Department of Primary Industries

Rix's Creek Mine Extension Project (SSD_6300) Response to exhibition of Environmental Impact Statement

Rix's Creek Extension project (SSD 13_6300) Response to exhibition of Environmental Impact Statement DPI Water – Detailed Comments

CALIBRATION MODEL – MODELLLED GROUNDWATER LEVELS VERSUS OBSERVED FIGURE 8.13

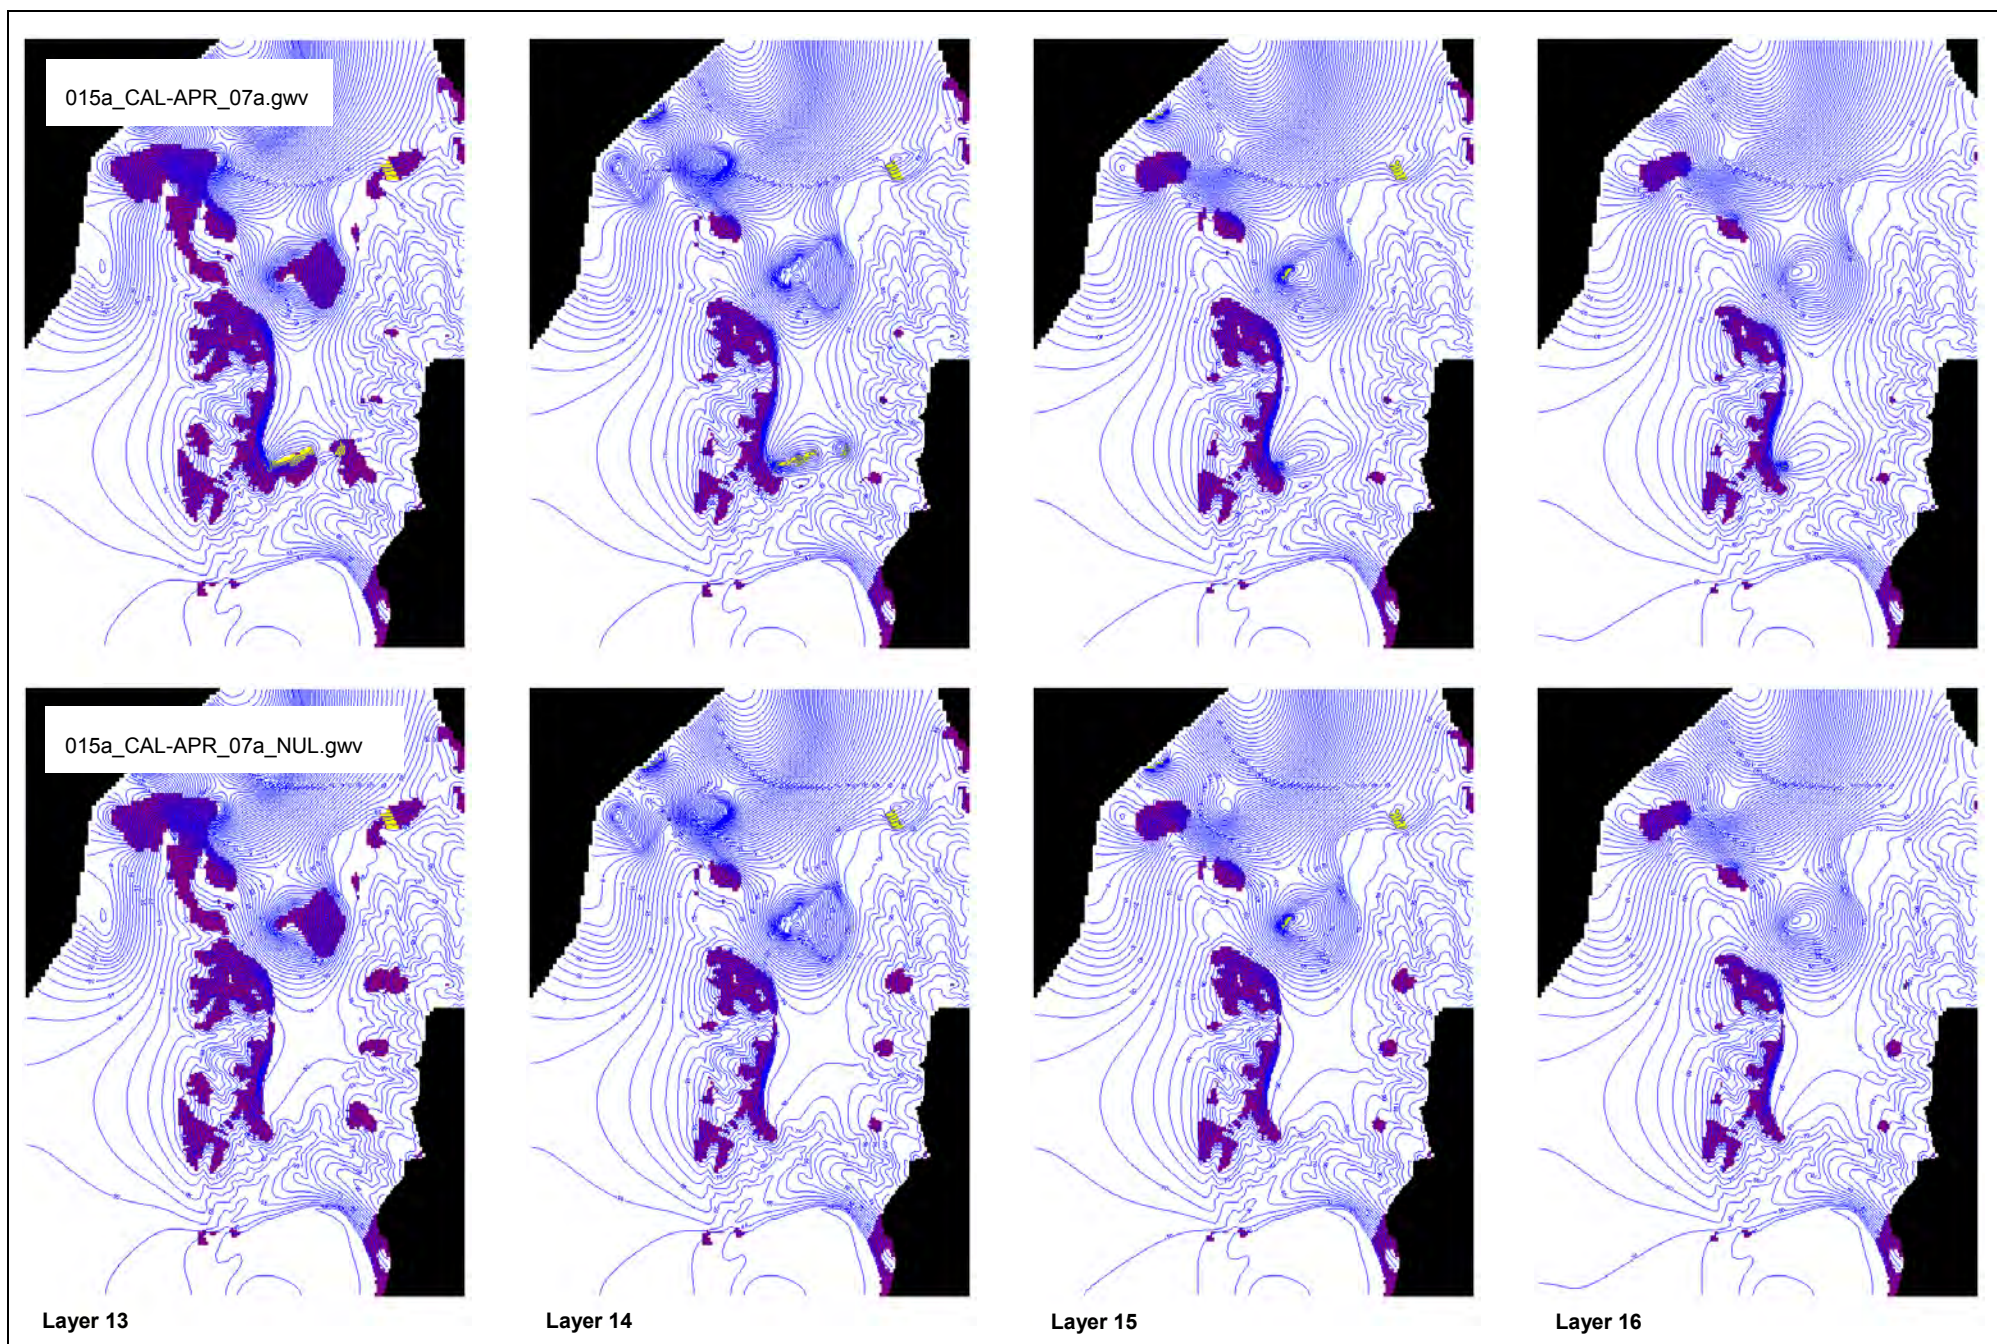
2. The model was not calibrated. A scaled root mean squared error (SRMS) of 16% was achieved. The Australian Groundwater Modelling Guideline recommends ~10%. The calibration hydrographs were not legible so no analysis of the calibration was performed by DPI Water.

Predicted Mine Inflows - Figure 9.1

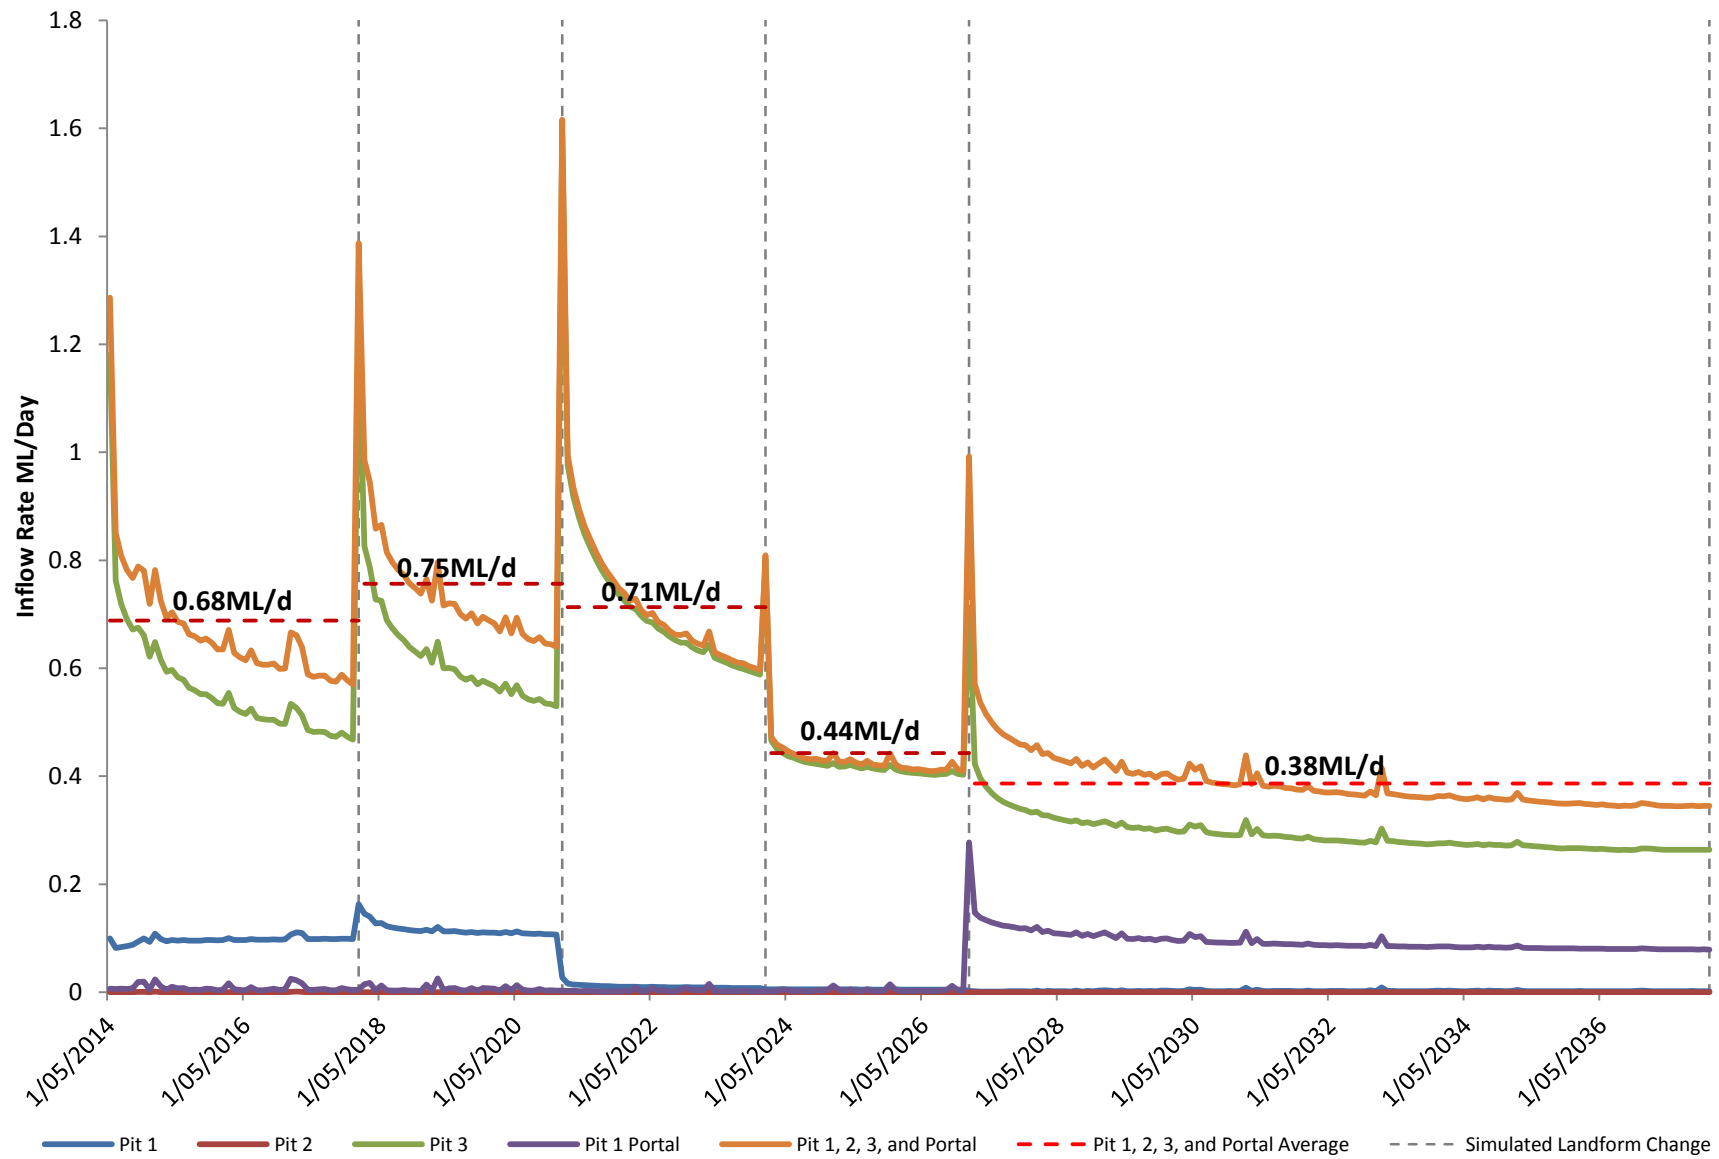
13. There is uncertainty why the model experiences such instantaneous, rapid increases and declines in inflows into the pits as shown in Figures 8.11; 8-16 and 9.1 and discussed in Sections 8.7.3; 8.8.2 and 9.2.1 respectively. Clarification is sought from the proponent to show that these artefacts are indeed related to the progressive implementation of the mine plan, pit development and back filling and are not related to model instability.
